Our Ref: SDNP/19/01425/ADJAUT
Contact Officer: Sarah Griffiee

Neighbouring Authority Consultation

Proposal: WA/23/19/DOC - Approval of details reserved by condition imposed under ref WA/84/17/PL relating to Condition Nos 4 vehicular access and 6 external lighting.
Address: Fairmead Farm Land , Binsted Lane , Arundel , BN18 0LQ ,

RA / 674 / 100 D

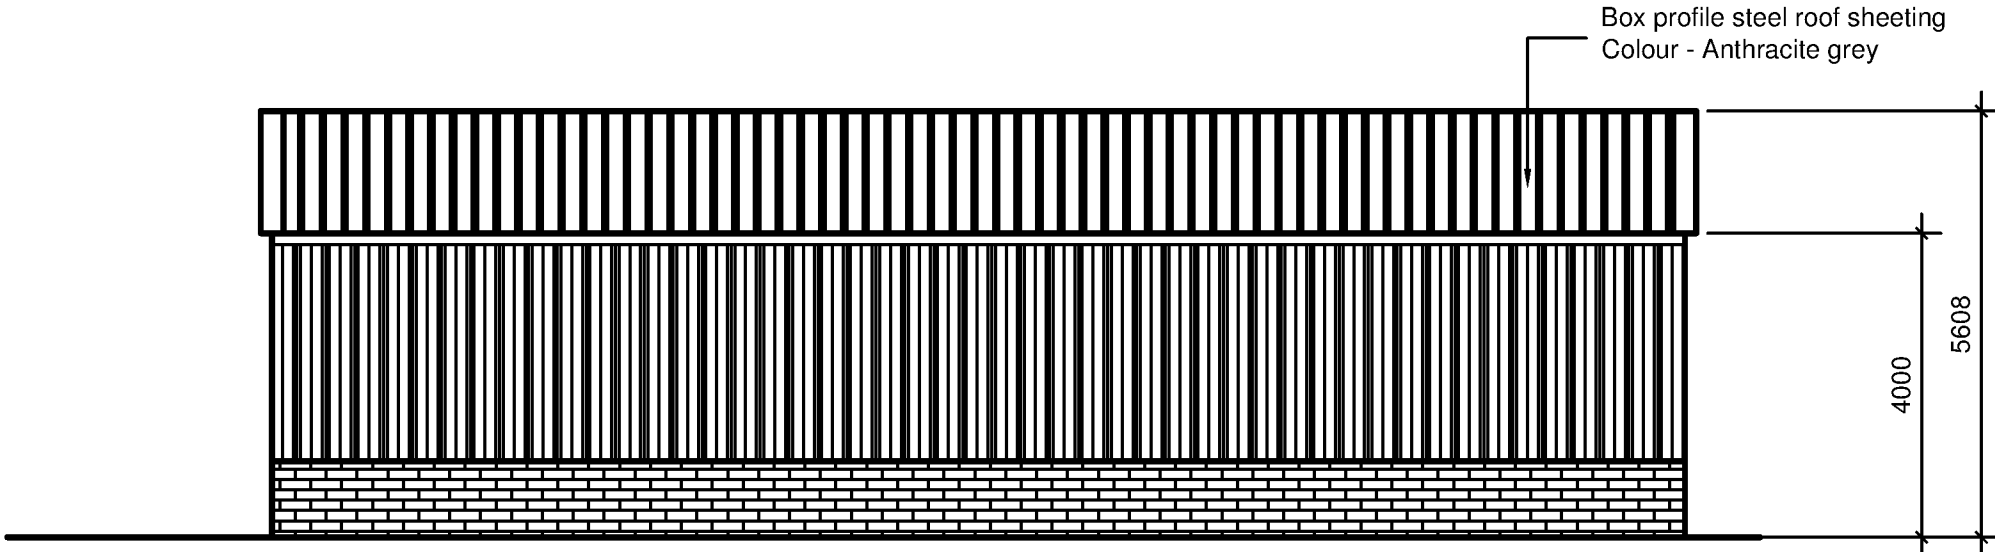
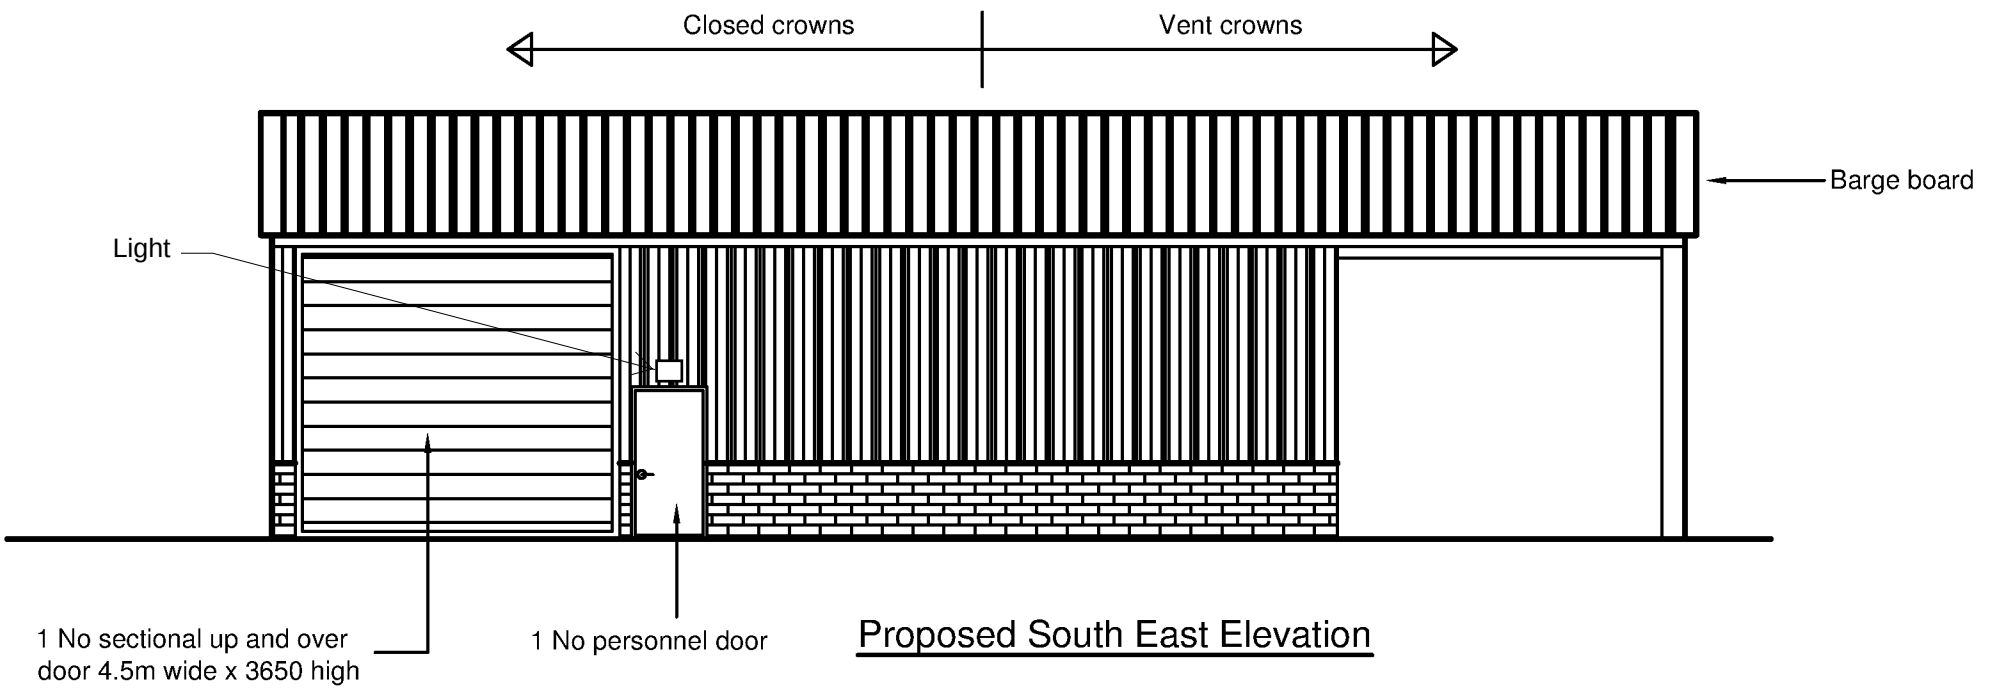
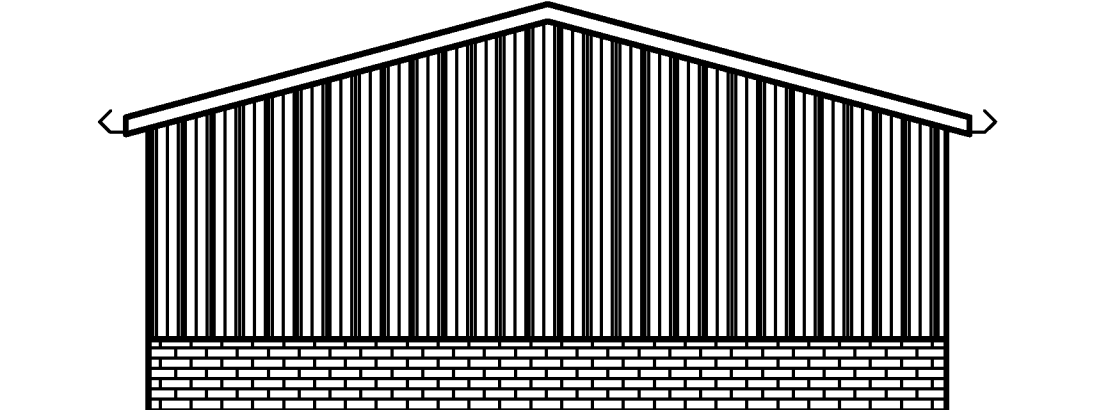
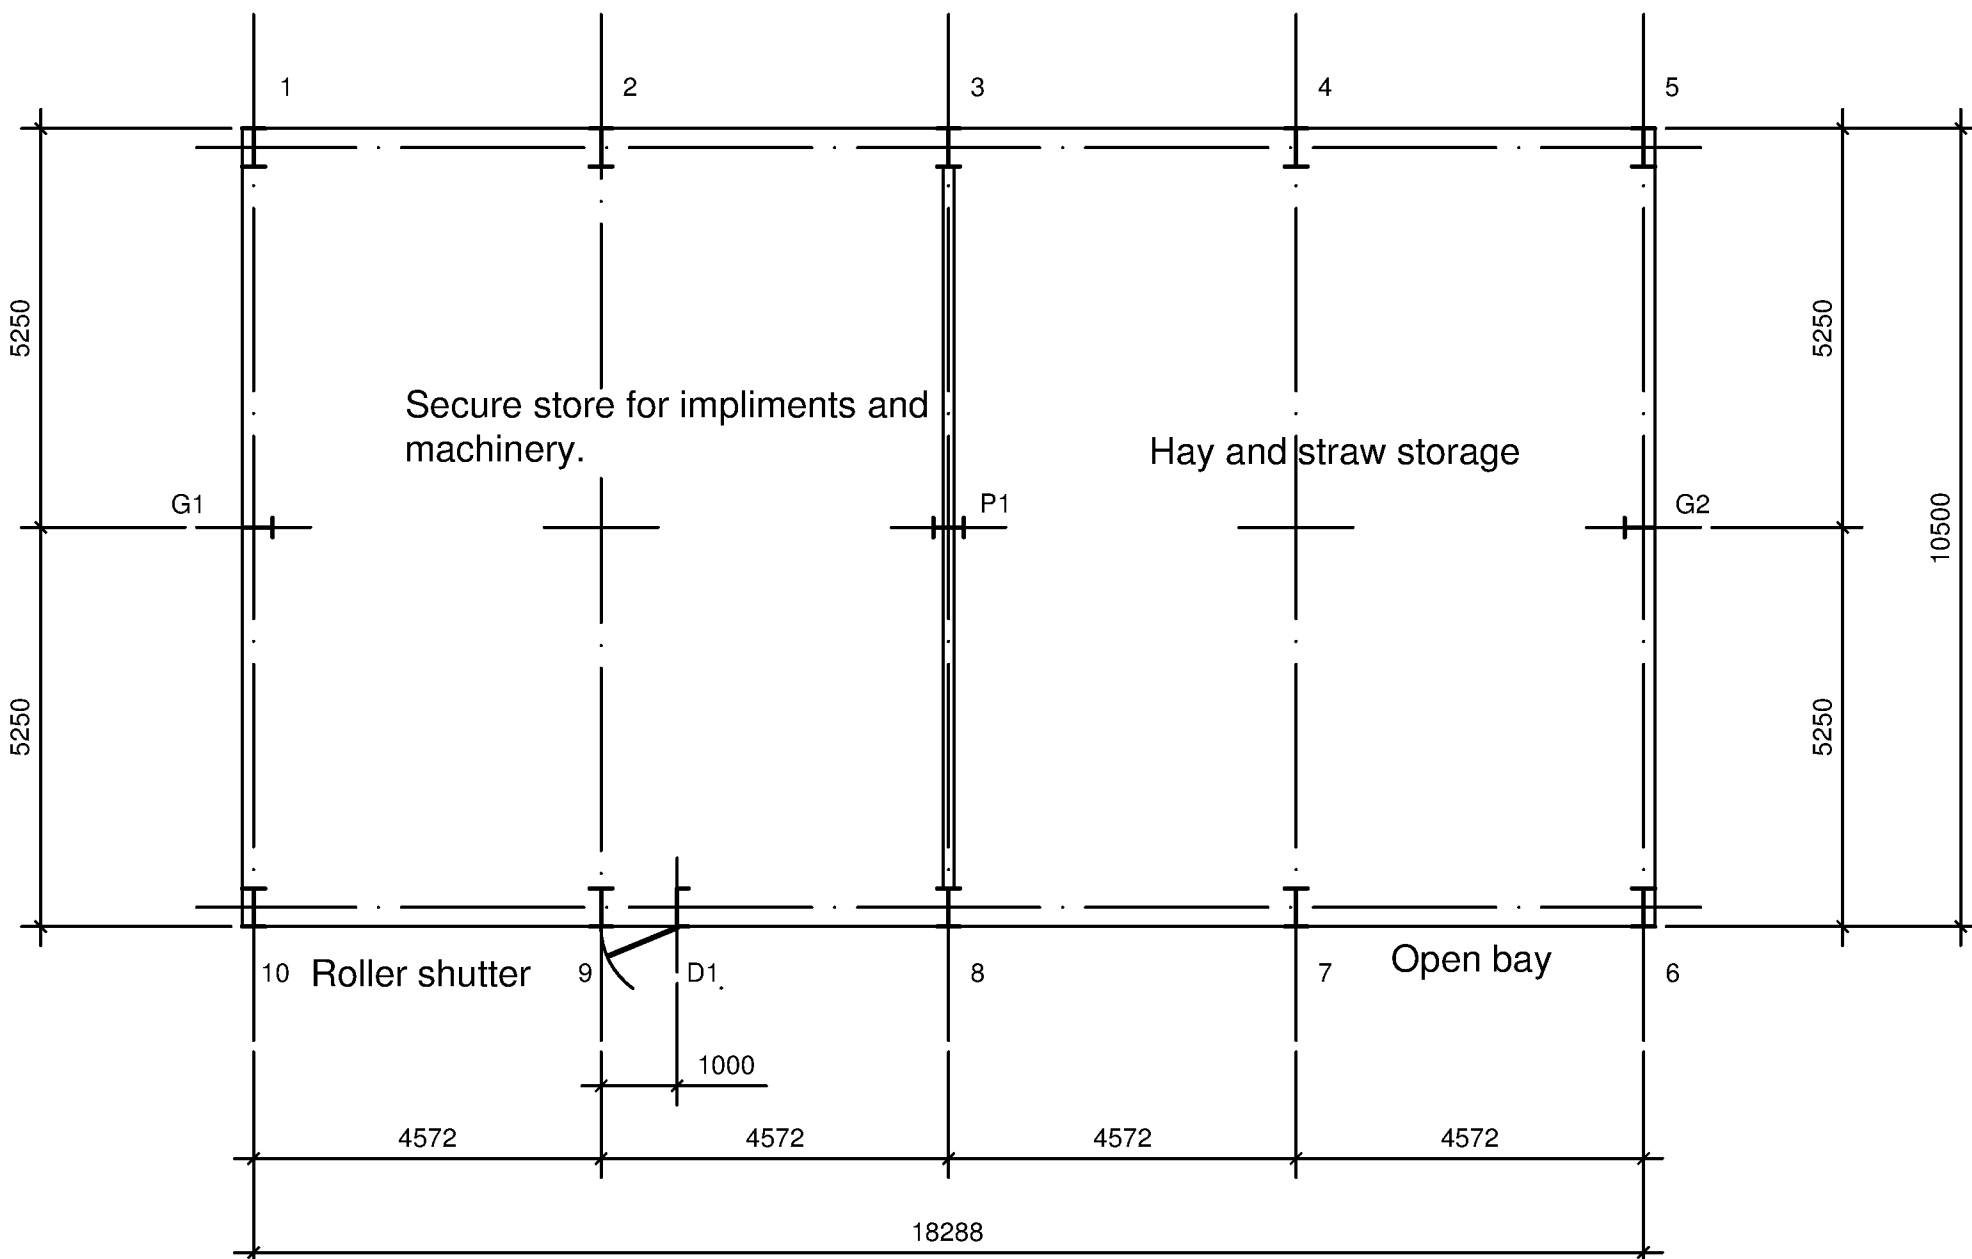
The proposed barn is located more than 200m South of the Dark Night Skies Reserve and further from any designated core areas. However, the impact on external lighting on ecology is still a material consideration. The submitted lighting statement shows the proposed type of lighting but does not confirm details of where or how many are to be located on the farm building. The use of directional downlighters is supported, but the cumulative impact should be considered.

SWEPT PATH ANALYSIS USING A
PICKUP TRUCK + TRAILER

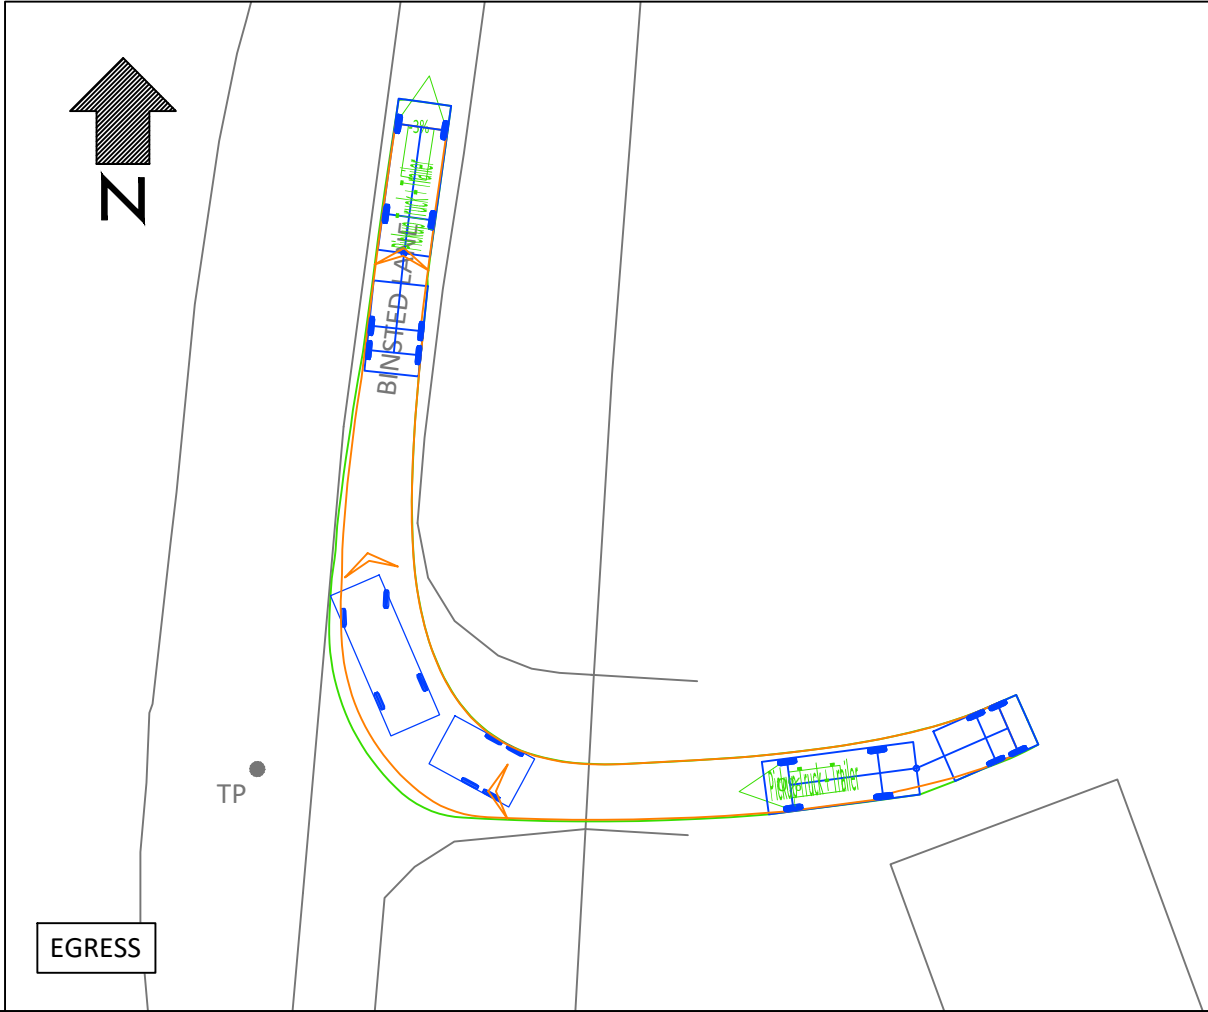
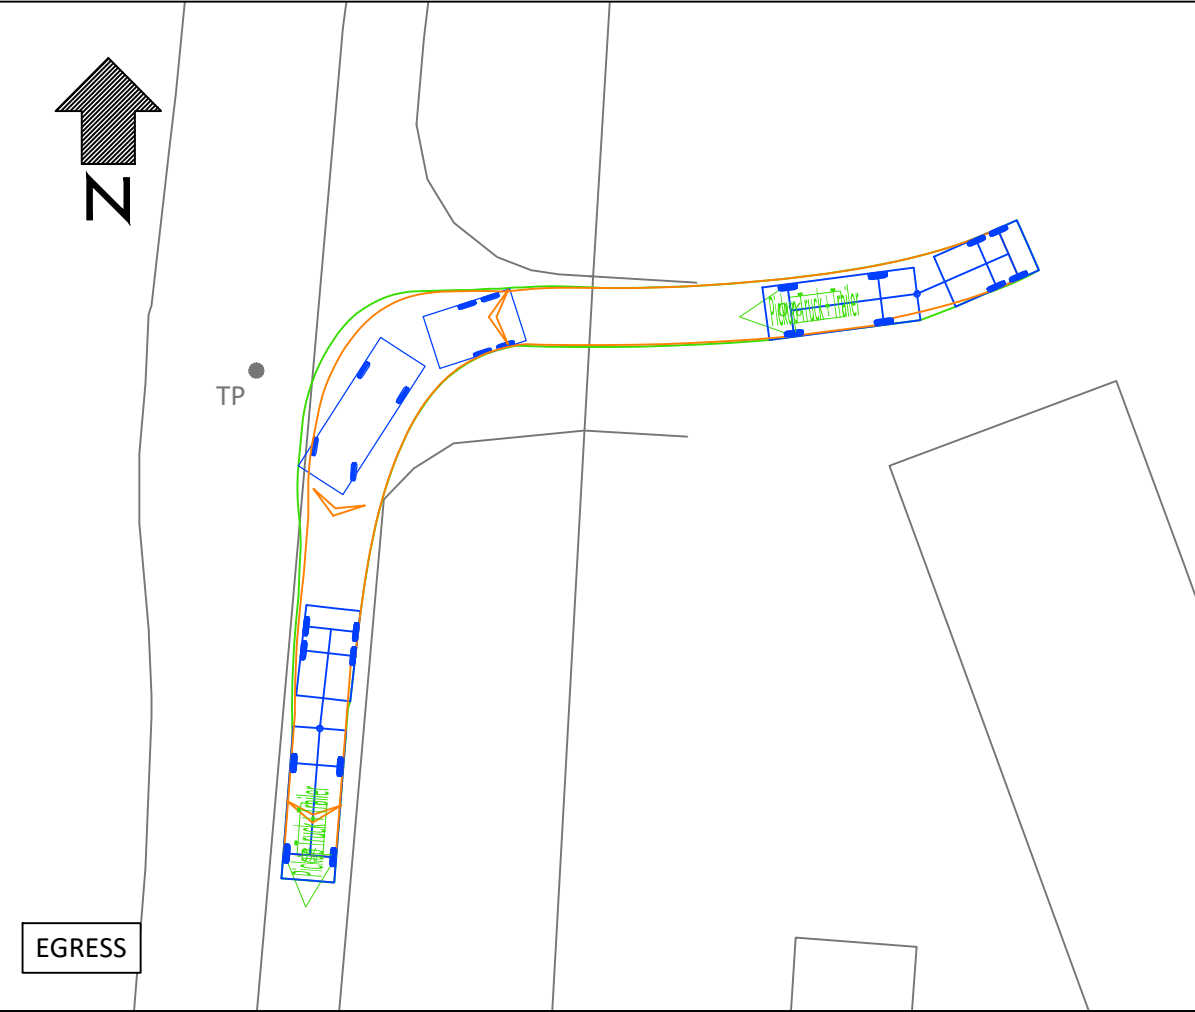
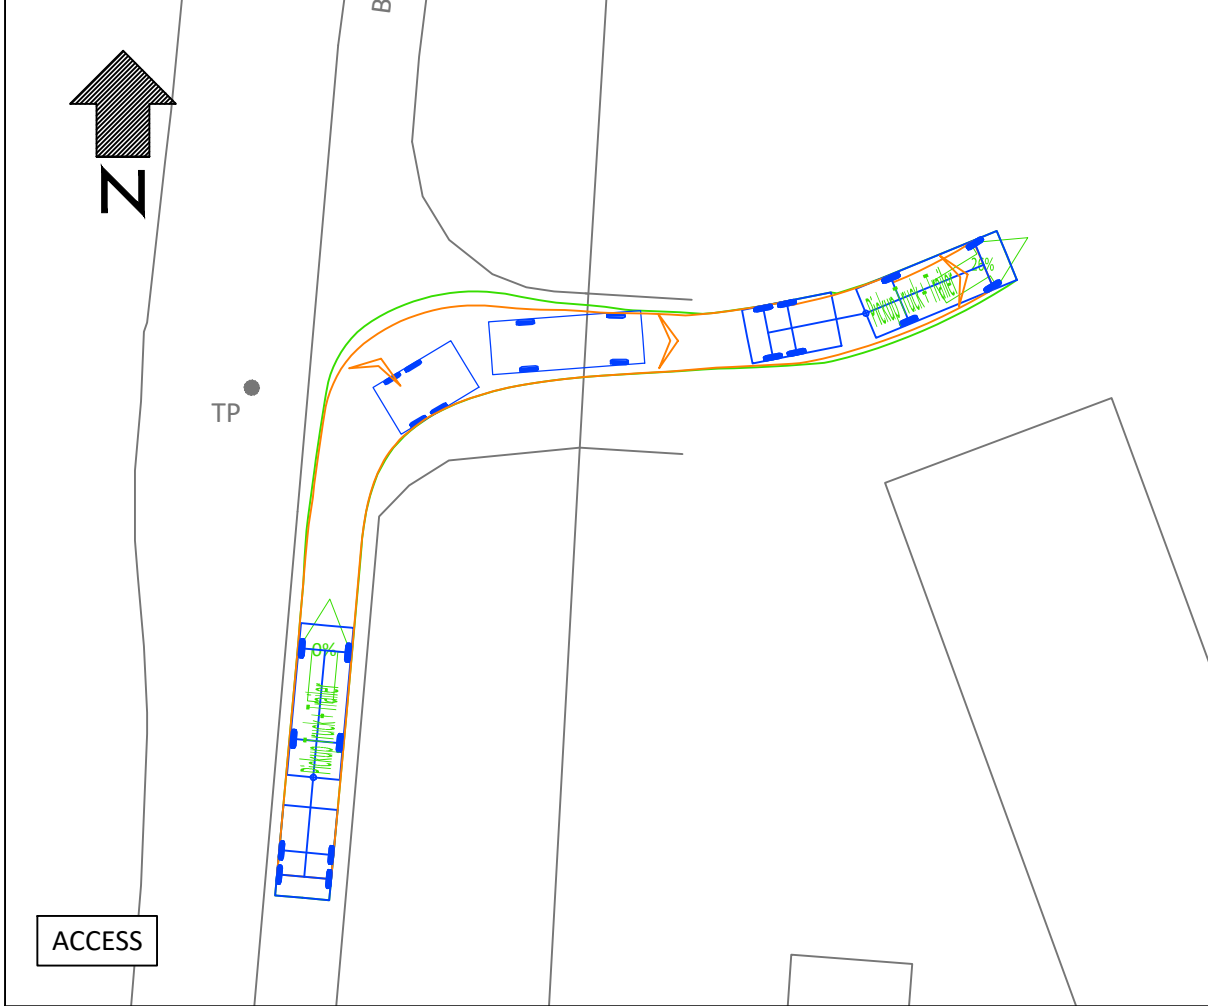
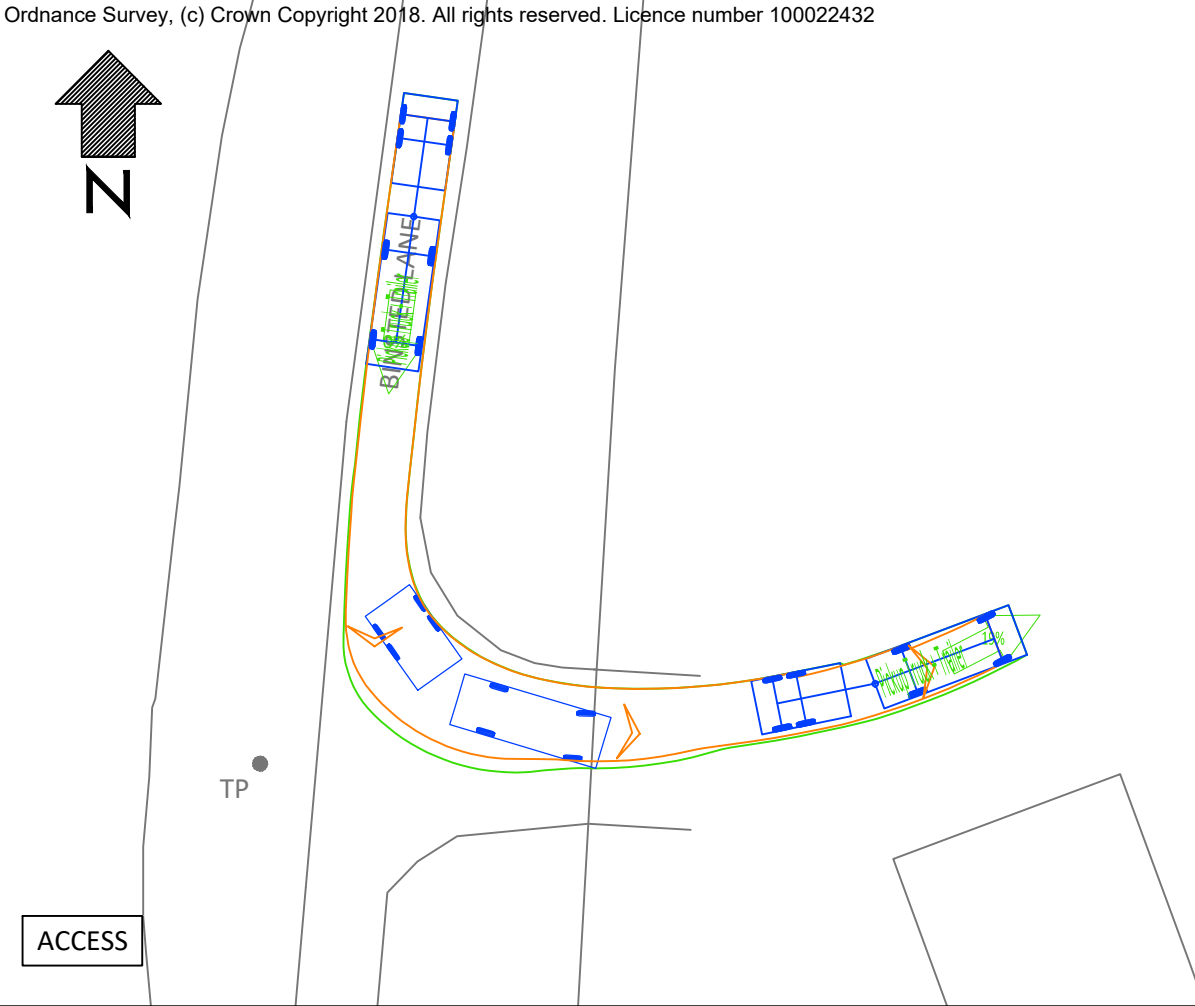
In regards to vehicle access, the swept path analysis shows that the size of the access is limited to that which is necessary for functionality. It is recommended that Highways are consulted on this to provide specialist comments. In regard to the appearance, a low key access is recommended without a formalised kerb to reflect the rural, countryside location and the character of other existing accesses along the road.
